# Subdivision PH Comments

**Date:** 02/23/2018

**RE:** Mitchell SP-17-00003 (Correction to comments submitted 2-12-18)

NANEUM ROAD SHORT PLAT  
 PART OF SECTION 33, T. 18 N., R. 19 E., W.M.  
 KITTITAS COUNTY, WASHINGTON

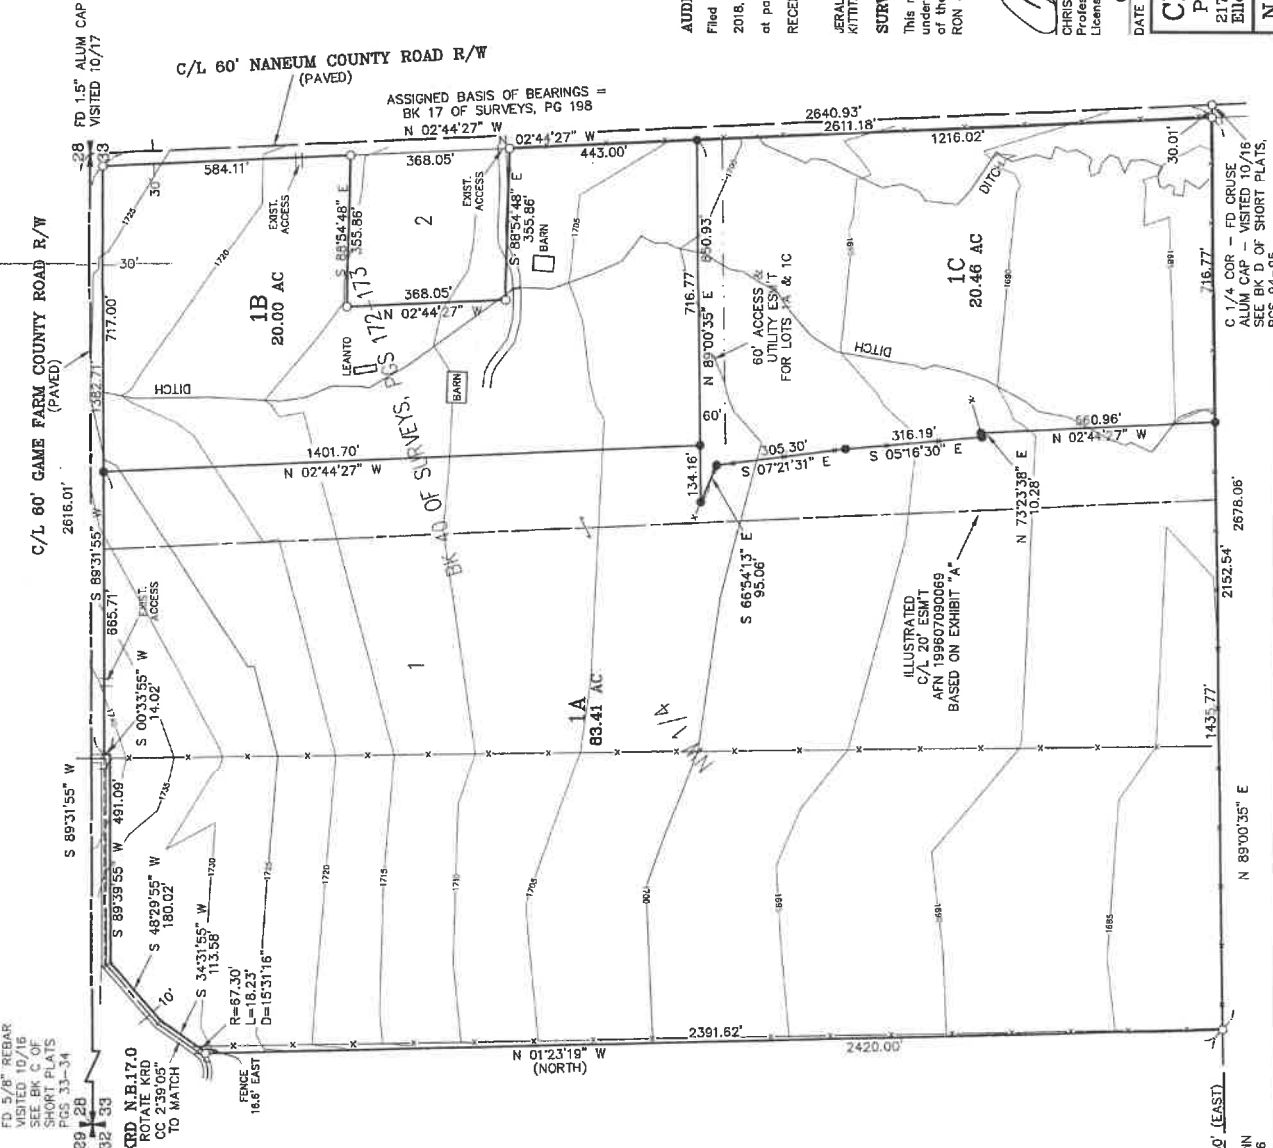
16. Well location. The drawings shall be marked with a "w" indicating location of the well and a broken line showing the one hundred foot radius around such.

All wells must meet the distance requirement of 50 feet from the property line, 50 feet from the septic tank and 100 feet from the drain field as per Kittitas County Critical Areas Ordinance 17A.08.25, and KCC Chapter 13. If existing wells do not meet the setback requirement from property lines, the two adjoining parcels nearest the well must enter into a legal, shared well-users agreement.

**16.12.030 Existing conditions – Unless otherwise indicated, the following shall be shown on the preliminary and final drawings.** (7) One soil log shall be performed and information recorded for each lot within the proposed subdivision. Soil logs shall be in accordance with WAC 246.272A.

(9) **A statement regarding the contemplated sewage disposal, potable water supply, and drainage improvements for the proposed subdivision.**
